Memorandum

Date: February 20, 2020

Re: Comment Responses for Springhill Suites Hotel Minor Amendment

This memo outlines the revisions made from the original submittal of this site plan amendment in response to staff comments received from the Transportation Development and Hydrology Sections.

IMM012 PROJECT NUMBER **A10.00** SHEET NUMBER

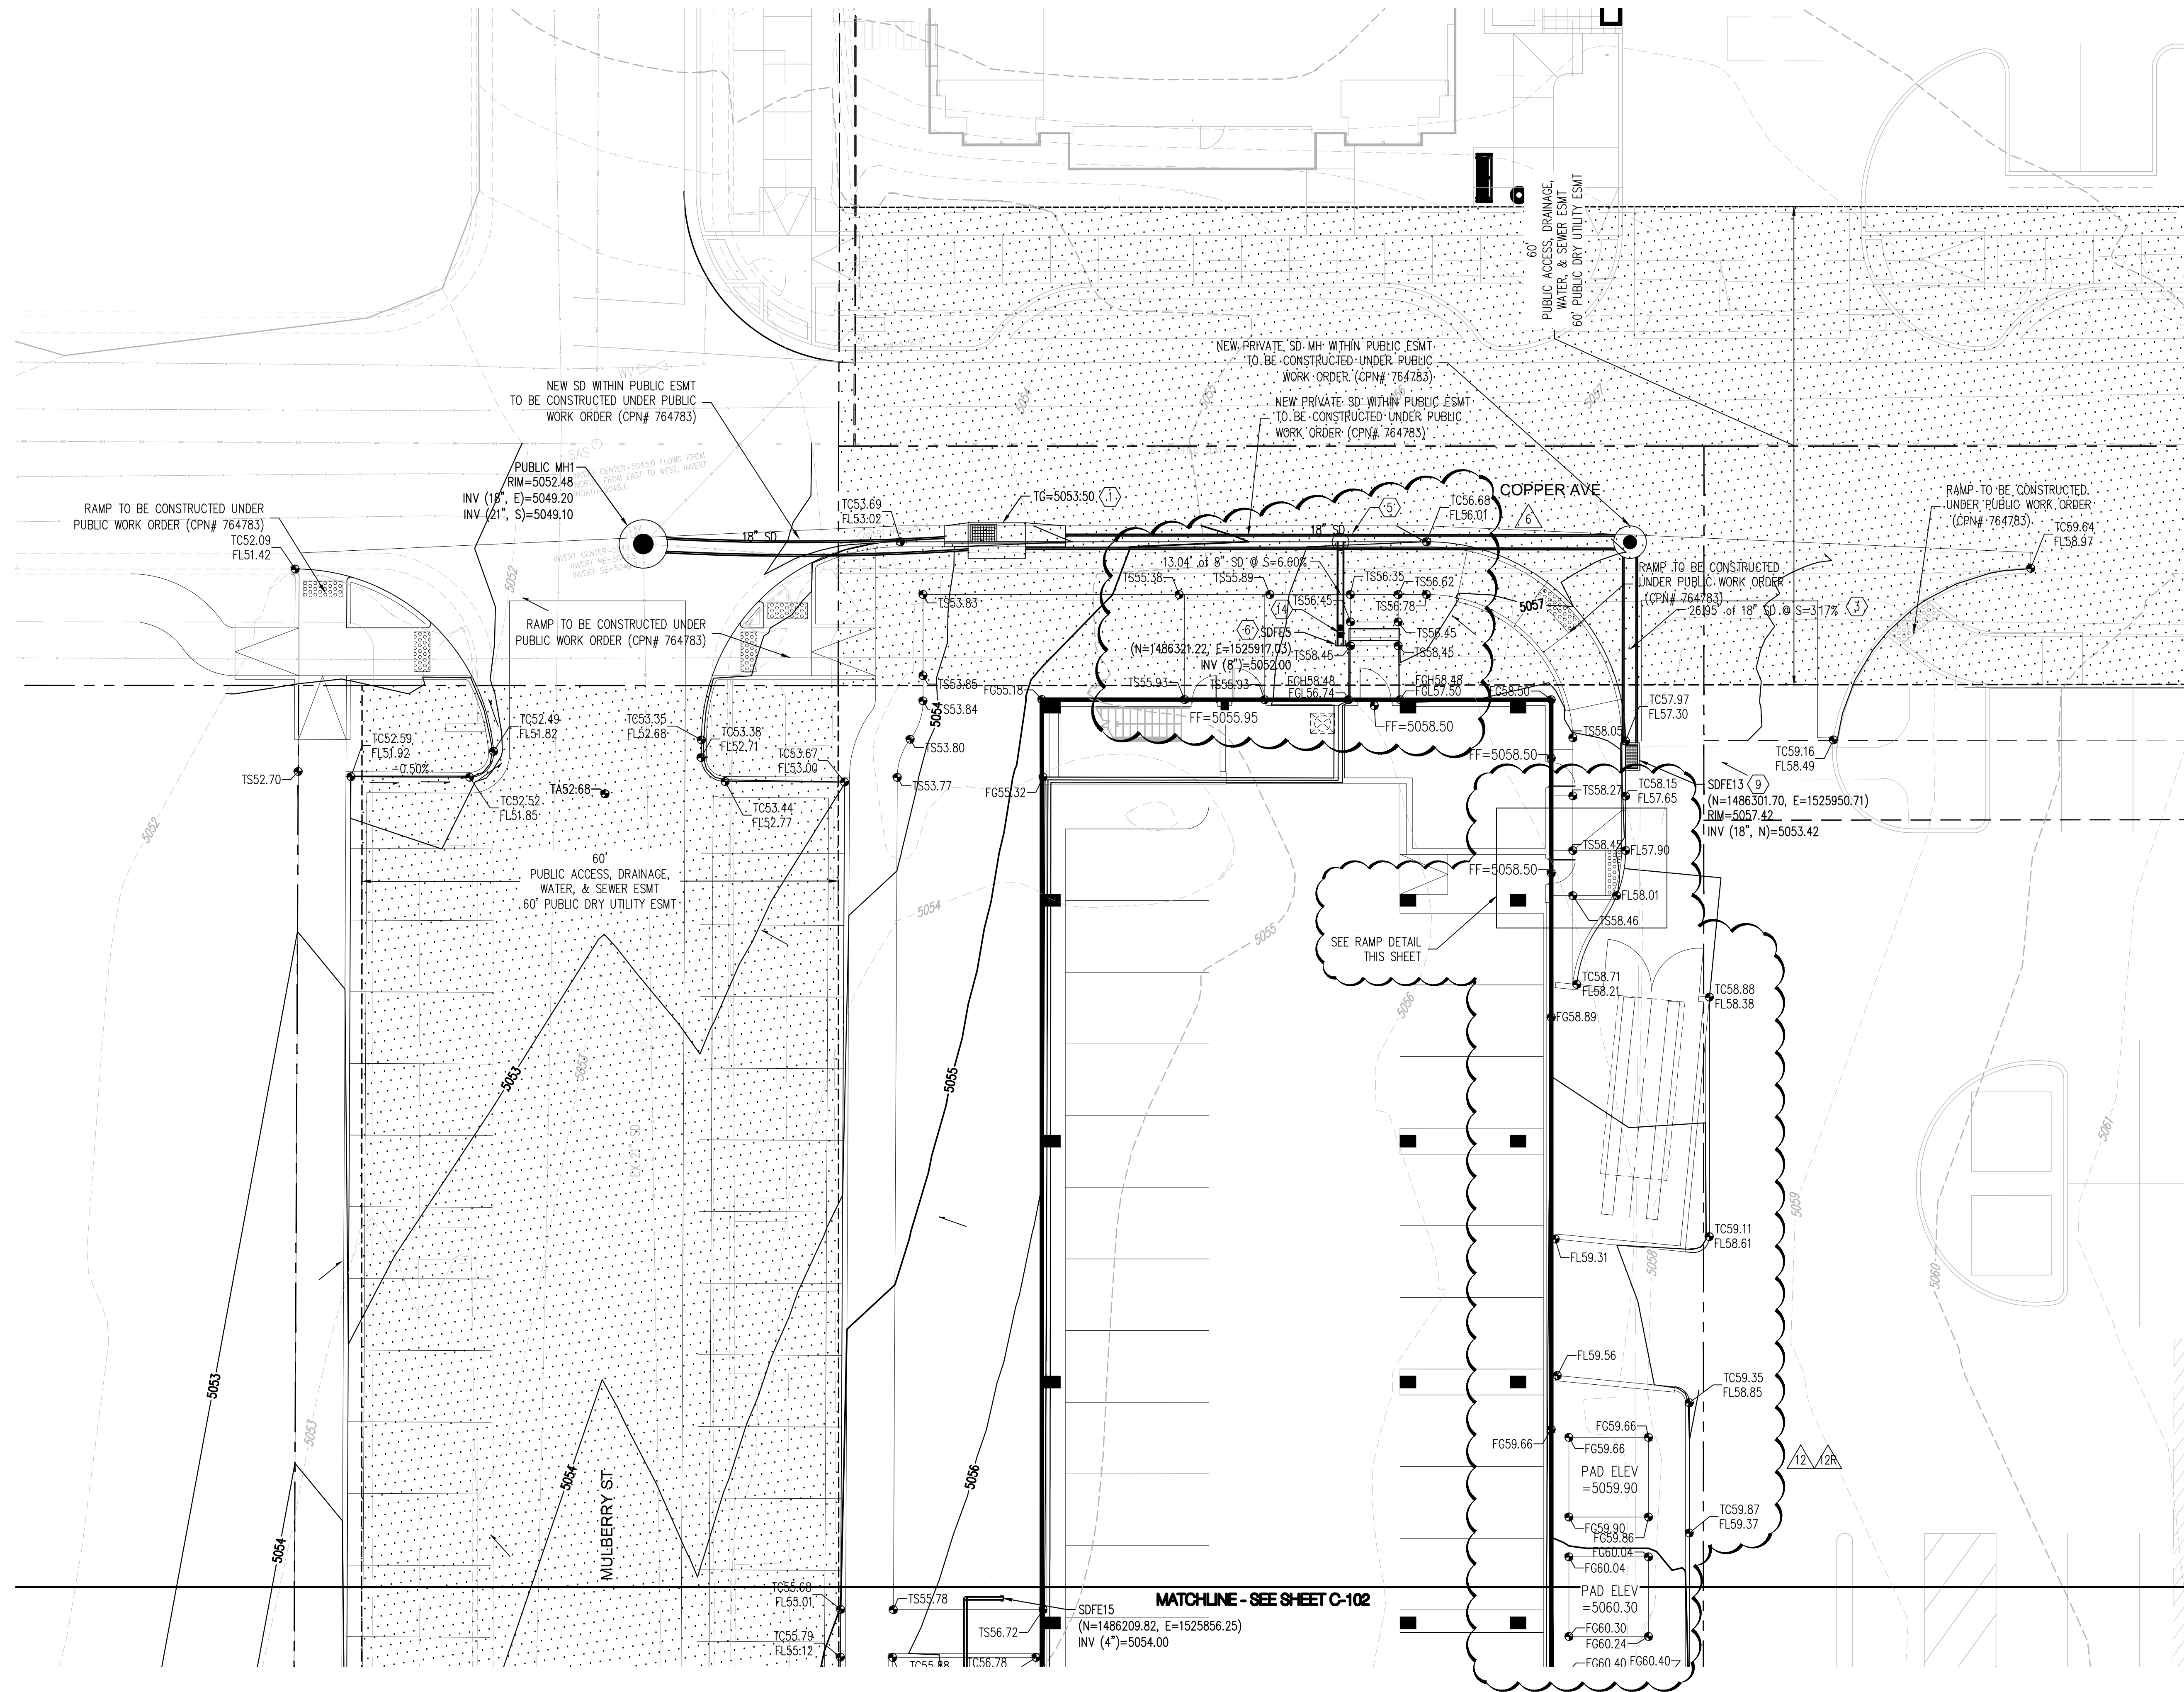
1. Clarify/show size of drive entrance where the trash dumpster is? (Graphically show entire driveway entrance.) Does that remain the same as what is shown on original plan? Where does the overall new site plan end on east end?

3. Provide curb ramp detail for curb ramp by dumpster and radii information.
 - a. *Radii (15') has been identified on the site plan. A detail for this ramp has been added by the engineer to Sheet C-101, which has been added to the amendment plan set.*

4. Provide handicapped parking signage and detail. Call out on plan.
 - a. *A detail sheet was included in the original plan that included typical stall layout, signage and locations, and painted markings. This detail sheet has been added to the amendment plan set.*

5. Provide "No Parking" as a pavement marking for the van accessible aisle.
 - a. *Typical accessible parking stall detail includes this marking.*

- a. *The proposed driveway remains the same width as what was previously shown in this location of the original plan. We have adjusted the line weights to better graphically show the adjacent property, which is being reviewed under a separate application, including a TCL. A dimension for the driveway width has also been included.*
